WEST SUSSEX COUNTY COUNCIL CONSULTATION

TO:	Arun District Council FAO: Susan Haley
FROM:	WSCC – Highways Authority
DATE:	6 May 2026
LOCATION:	35 North Bersted Street, Bognor Regis, PO22 9AA
SUBJECT:	BE/26/26/HH The proposal is to construct a new residential driveway at the front of property No. 35, North Bersted Street. The work involves removing a section of the existing grass bank and installing a ramped access driveway surfaced with 14mm grade stone chippings. The new drive will provide off-street parking and improved access to the property. The design includes a planted border, a low retaining wall with natural stone facing, and a rumble strip at the pavement edge. A vertically slatted screen with climbing plants will be positioned on one side to provide visual screening and maintain privacy. The development retains existing green features where possible and enhances the frontage with soft landscaping.
DATE OF SITE VISIT:	n/a
RECOMMENDATION:	Advice

This application is for ramped access across grass verge to create new driveway to front of property, including boundary treatments. The site is located on North Bersted Street, a C-classified road subject to a speed restriction of

35 North Bersted Site Plan

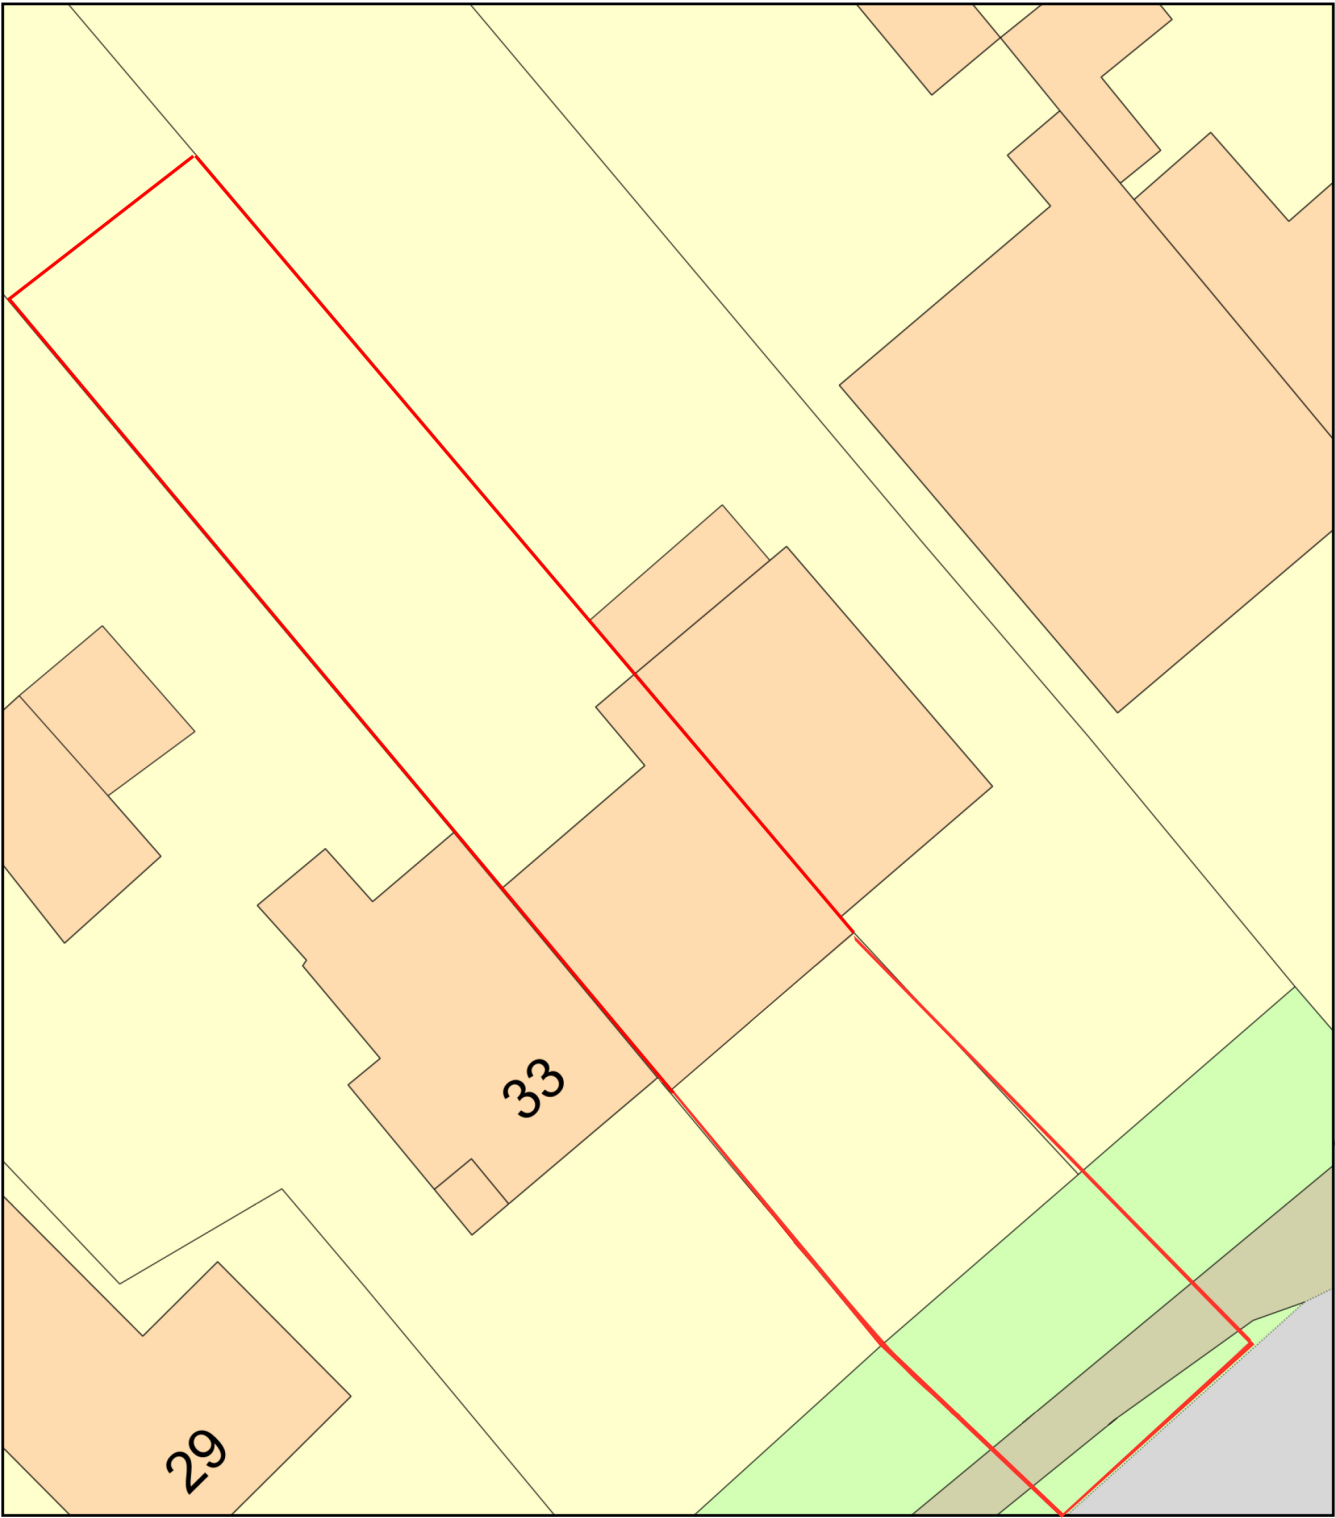
The applicant proposes a new vehicular crossover (VCO) on to North Bersted Street. The proposed access works will be subject to a licence obtained through the local Highway Area Office and constructed to a specification agreed with the local Highway Area Engineer.

The current WSCC Area Office policy does not permit the construction of vehicle accesses in parking laybys. This is to ensure that existing designated residents and visitor parking is maintained for all on a first come, first serve basis.

In addition to the above, the Area Office do not permit access that cross an expanse of grass verge, which may be considered an amenity area. The Area Office may consider any grassed area to be an amenity area; however, they are more likely to consider the length of grass/verge from the kerb to the private residence of 3.0m of grassed area to be an amenity area. The Area Office has been consulted regarding a VCO in this location and confirmed that it is unlikely that a license will be granted.

Notwithstanding the above, from inspection of local mapping, there are no apparent visibility concerns with the proposed access point. The proposed driveway is of suitable size to accommodate one car parking space. On-site turning does not appear achievable, so cars may have to exit the site in a reverse gear. However, this is not anticipated to give rise to any adverse highway safety impacts in this location.

Therefore, whilst no highway safety concerns would be raised for the proposals, the applicant should be made aware that they are unlikely to be granted a licence for the proposed access works, as the proposals are contrary to current WSCC Area Office policy.

The applicant is advised that in addition to obtaining planning permission that they must also obtain formal approval from the highway authority to carry out the site access works on the public highway. The granting of planning permission does not guarantee that a vehicle crossover licence shall be granted because the highway license process considers wider factors than are considered by the Highway Authority at planning stage.
